**Re: PA22-024- Marysville 44th PRD – Technical Review 1
7315 / 7417 44th St NE – APN(s) 30053500303700 / 30053500303600**

This letter is provided as response to comments dated August 17, 2022. Each item has been carefully reviewed and considered and the following is a summary of how each item was addressed.

DRAWING: **C2**
 SHEET: **2** OF **8**

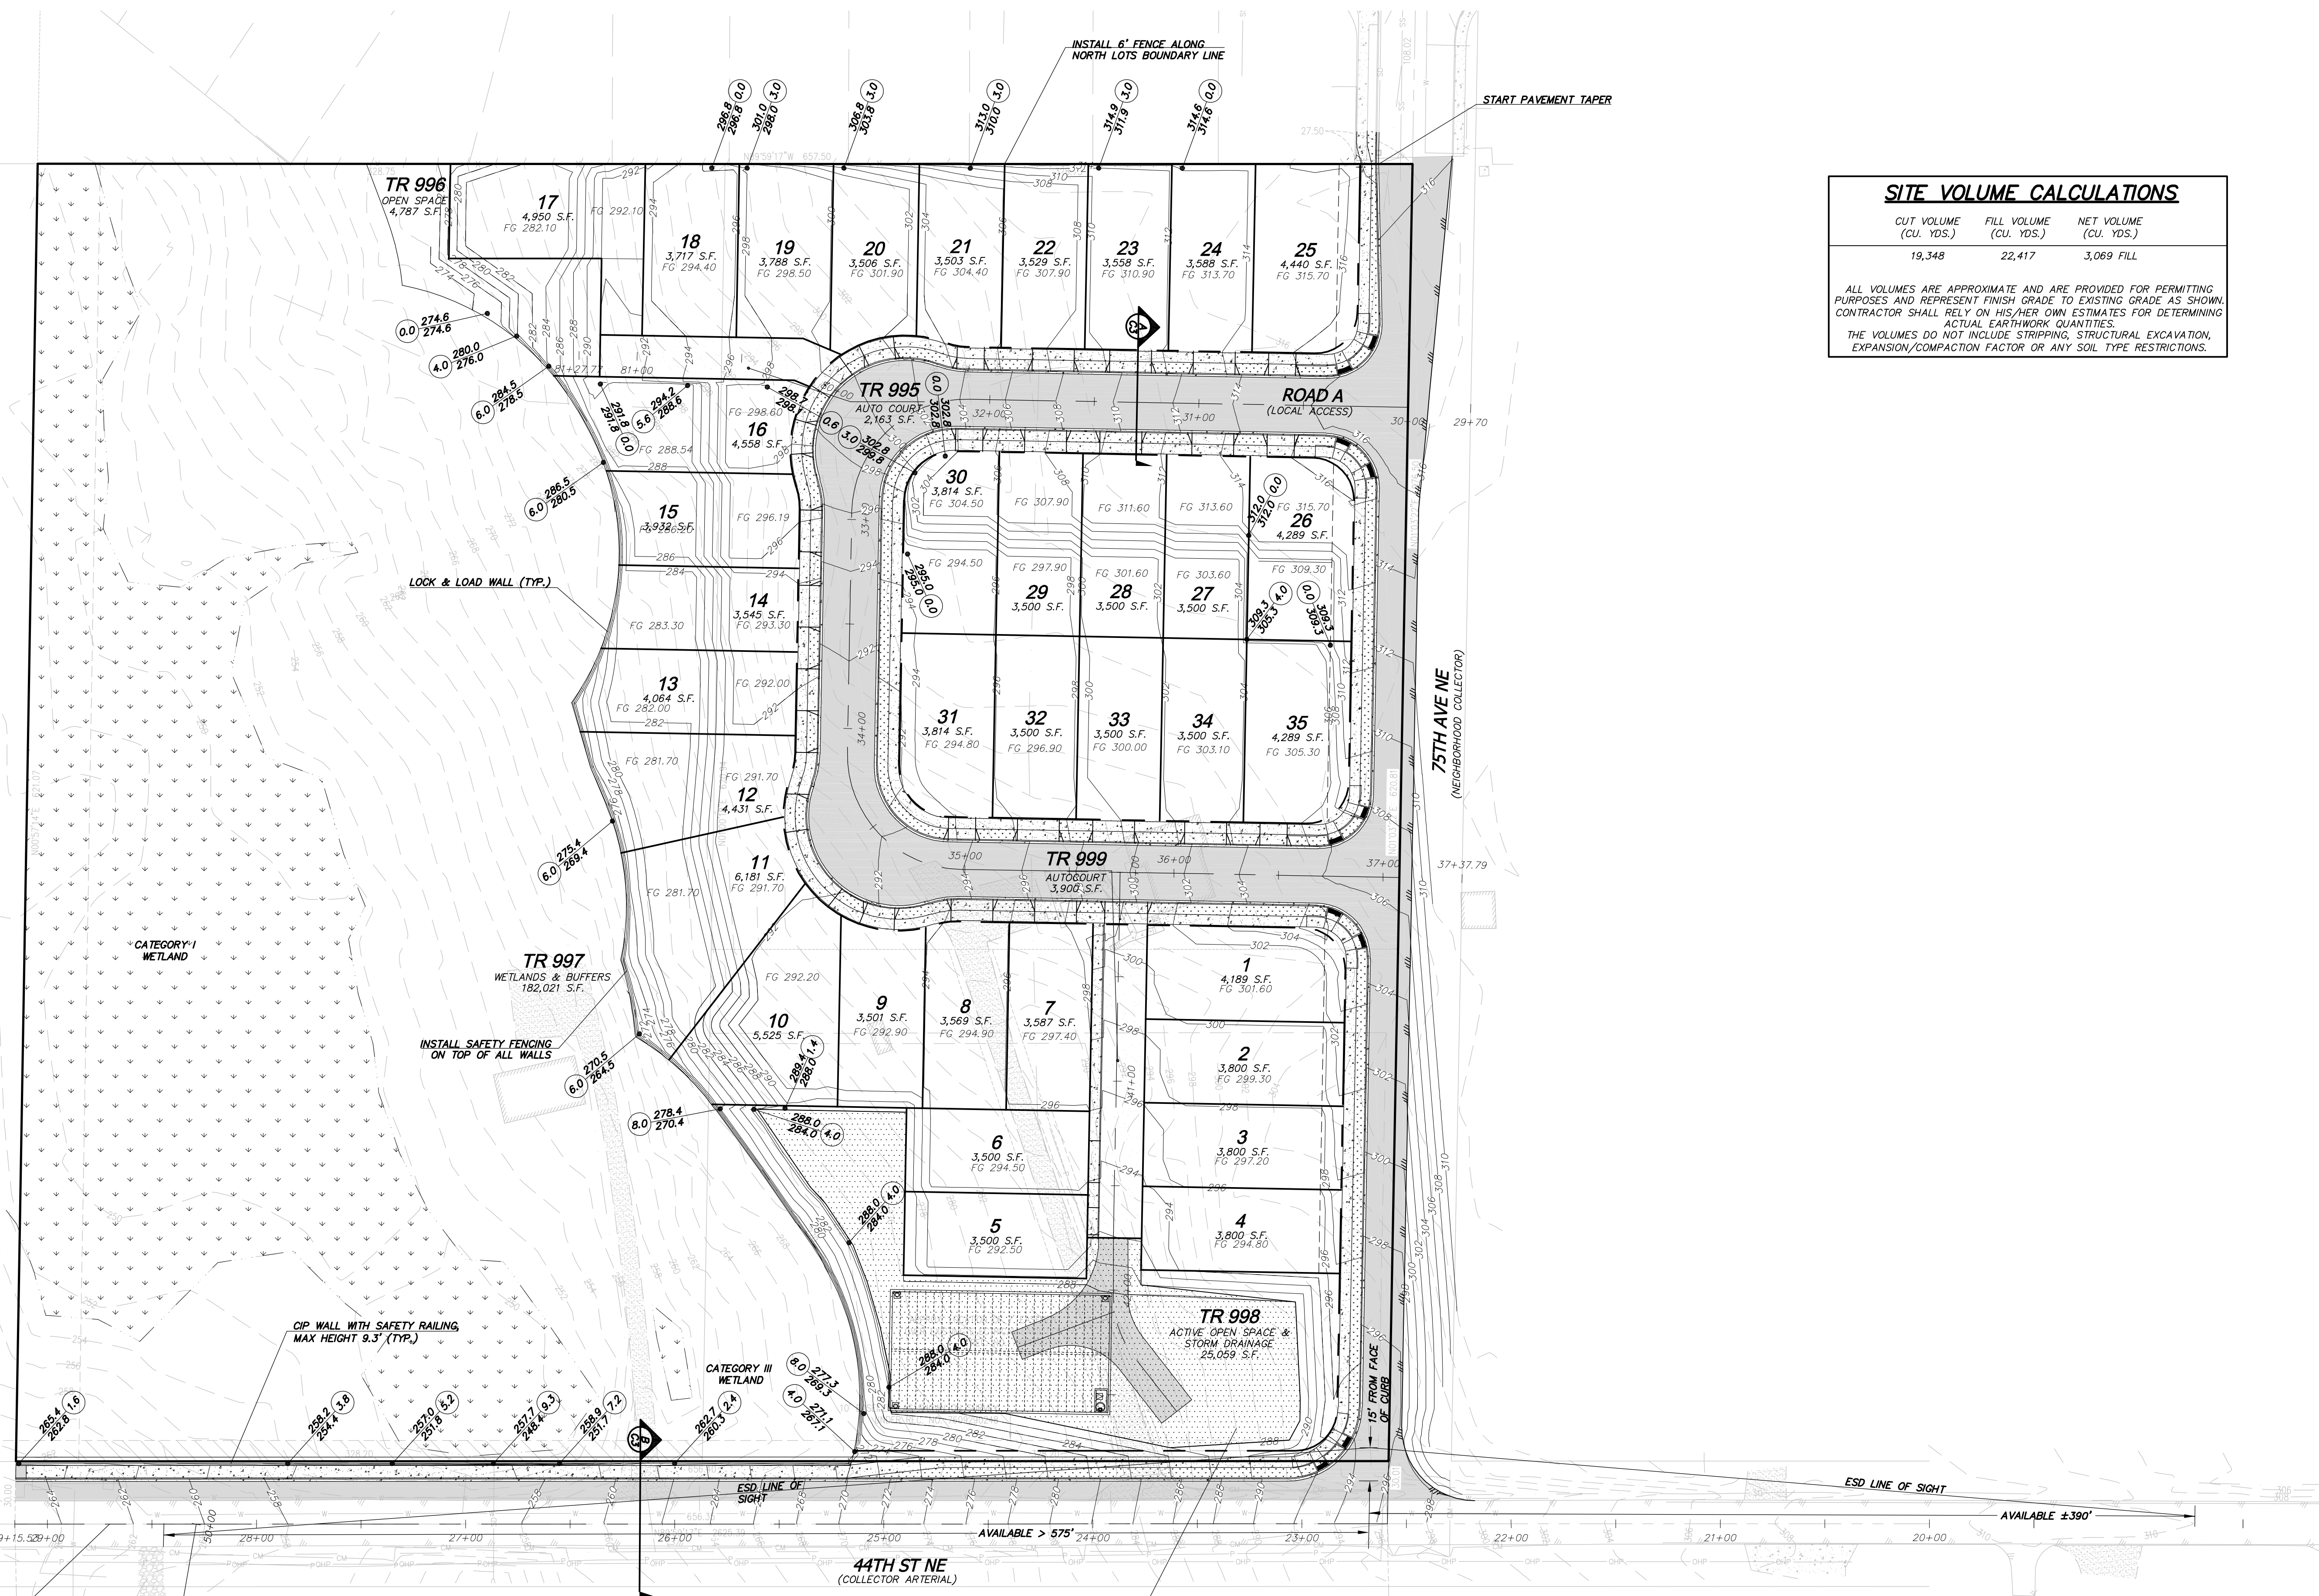
4.1. Please clarify how compliance with MMC 22D.050.030(4) is to be satisfied if the proposed retaining walls exceed 4 ft. in height. If the walls are to be terraced, the terraced sections are required to be separated by a 2 ft. landscaping bed. If terracing is required, add the 2 ft. landscaping bed to the landscaping plans.

- 4.2. Provide call out details for said walls and include wall symbols in legend.

- a. The wall end (or any wall end on site) located on the east side of the vault along the auto court must not have a grade differential of greater than 2'.

- b. Per MMC 22D.050.030 (4) Any walls taller than 4' that are visible to the street or adjacent property must be terraced.

Per our follow up meeting, most walls are ok being taller than 4 feet and not being terraced since they are screened by wetland buffer. Other walls will meet the terraced design.

Call outs are shown and wall has a symbol that is shown on grading plan.

Revised.

Revised.
